**WEST SUSSEX COUNTY COUNCIL
STRATEGIC PLANNING CONSULTATION**

SUBJECT: FG/52/15/DOC - Application for approval of details reserved by condition imposed under FG/145/14/PL relating to Condition No's 6, 7 and 12 - Materials Schedule & Samples, Landscape Layout & Access Layout.

22 & 24, Ferring Lane, Ferring, West Sussex, BN12 6QT

CLIENT	Globe Estates (Southern) Ltd
PROJECT	22 - 24 Ferring Lane, Ferring
TITLE	Proposed Site Access Arrangement
DRAWN	T Zajac
DATE	Feb 2015
DESIGNED	G Waller
CHECKED	GW
SCALE	1:250 @ A3
PROJECT NO	22426
DATE NO	200
REV	C

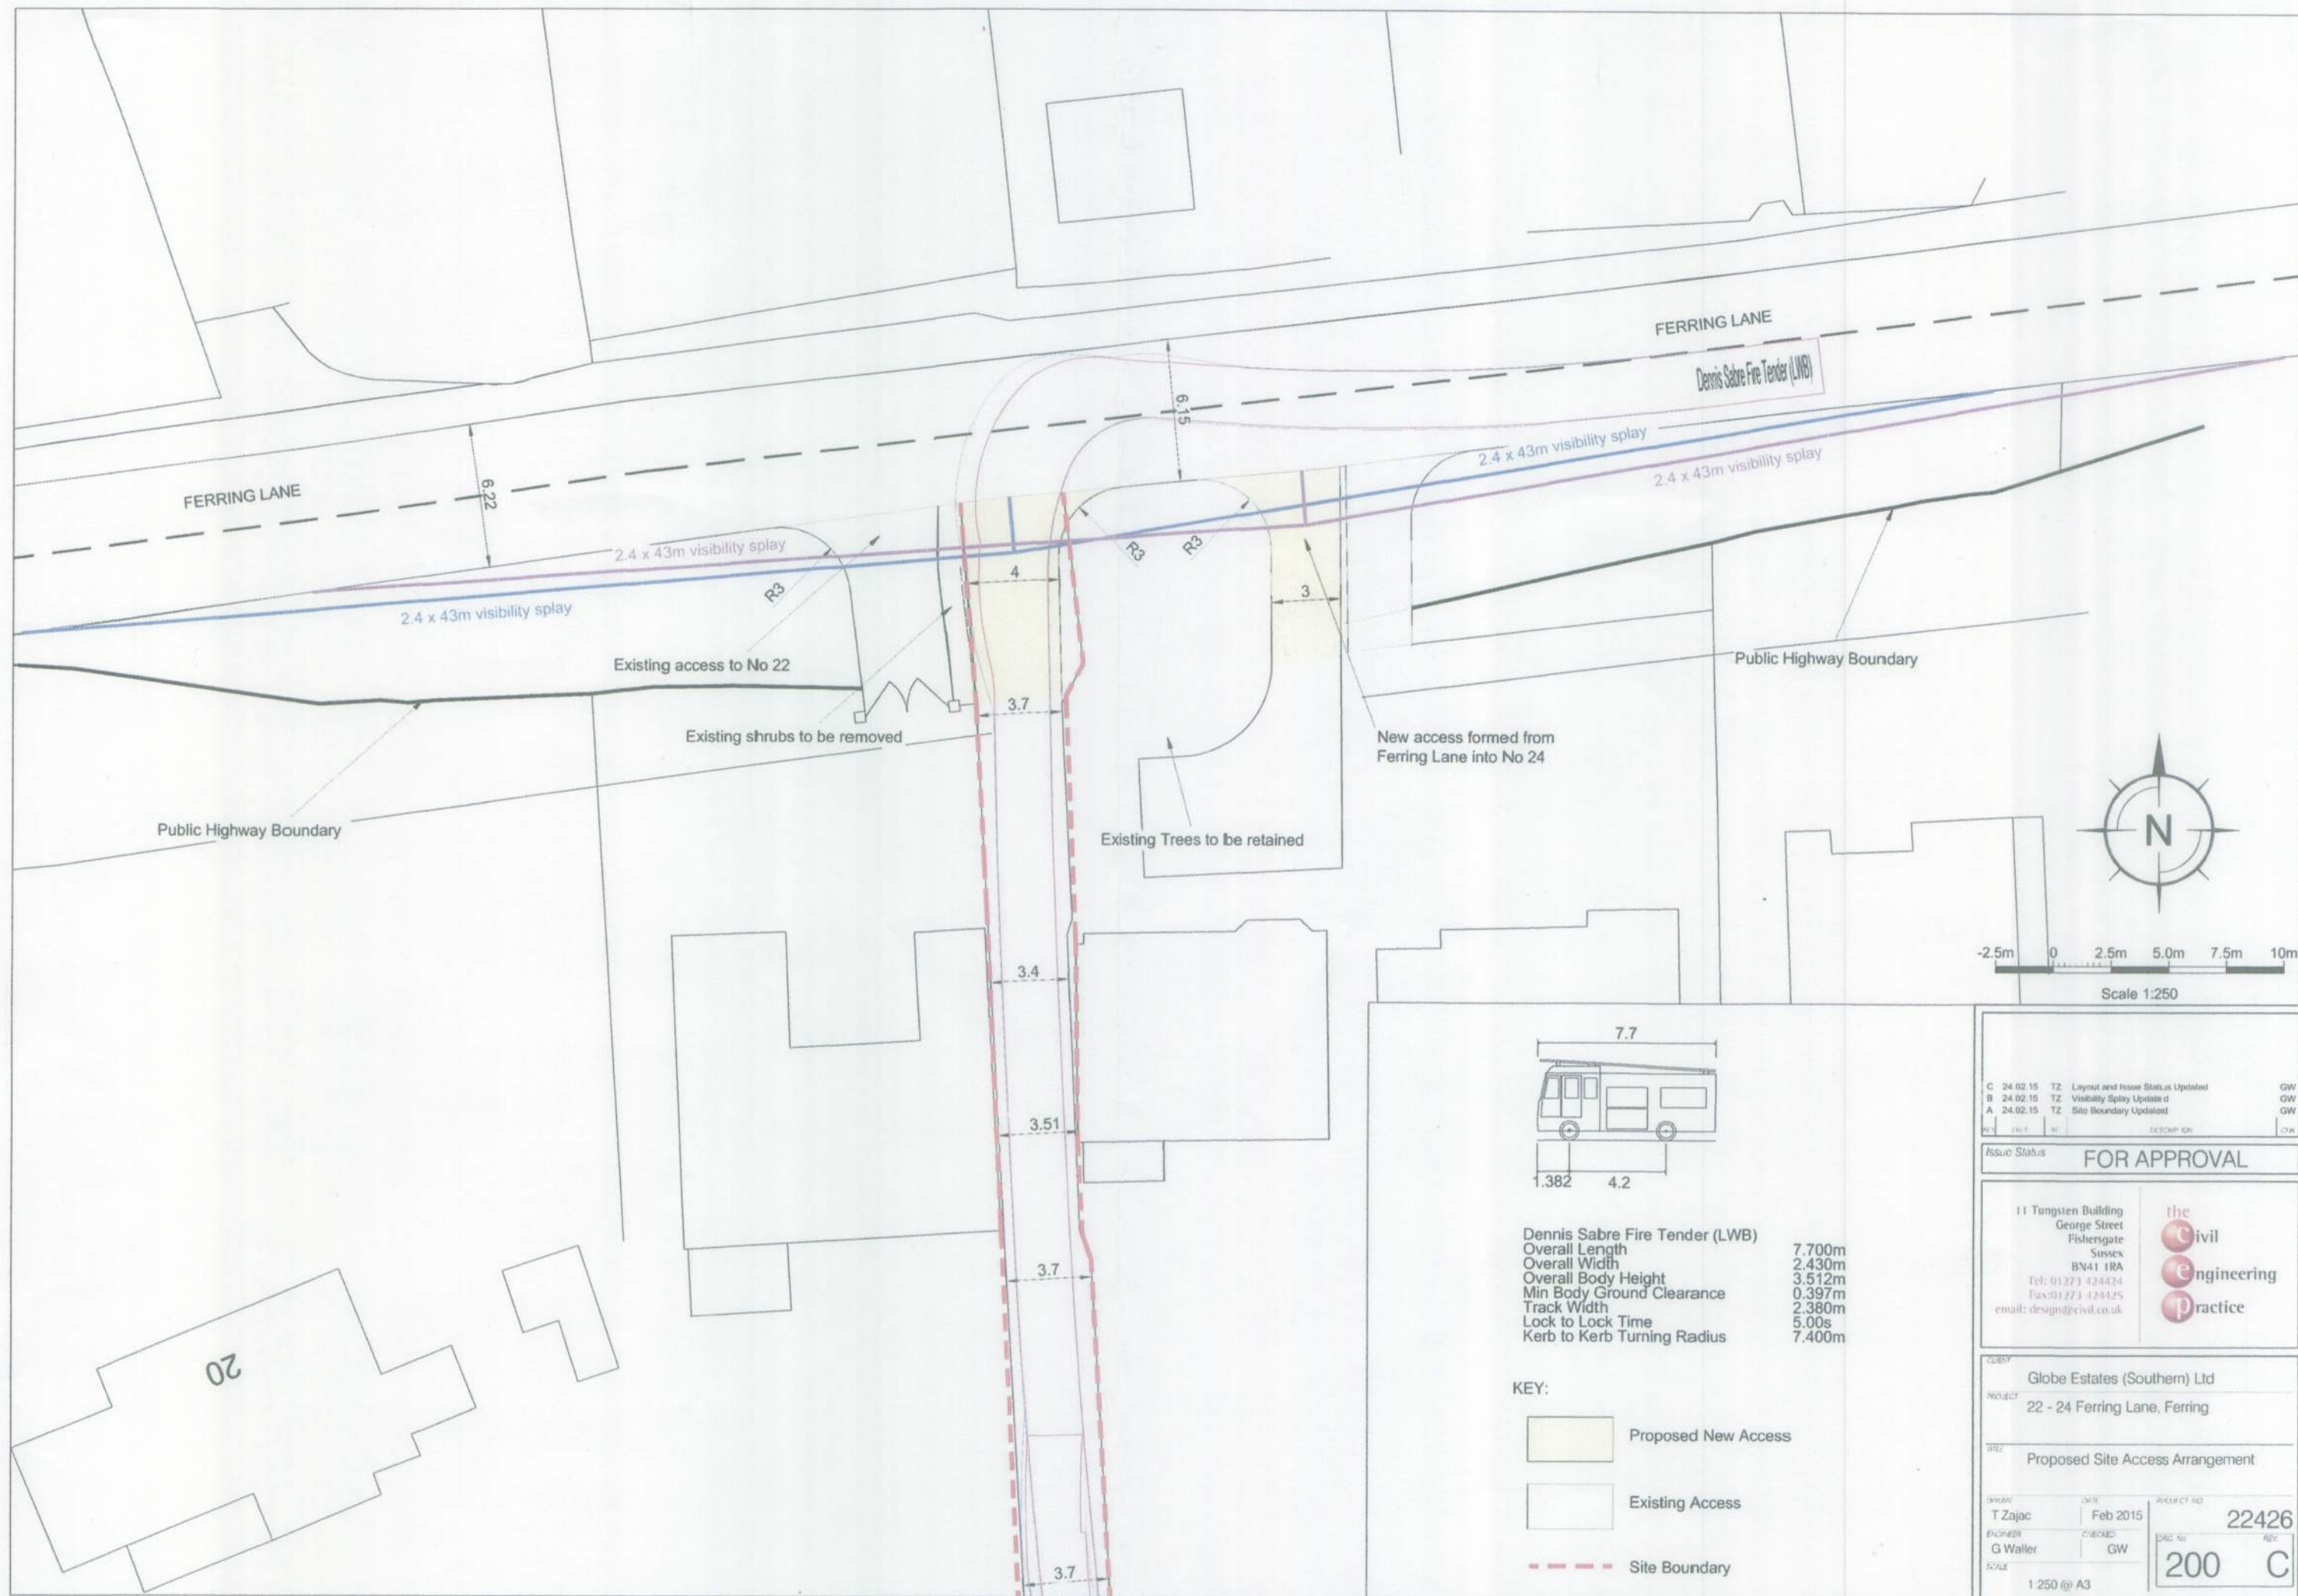
The applicant has provided a plan (Drawing 200 C) demonstrating the existing and proposed points of access. Details pertaining to access width, radii and visibility splays would all be considered acceptable in highways terms.
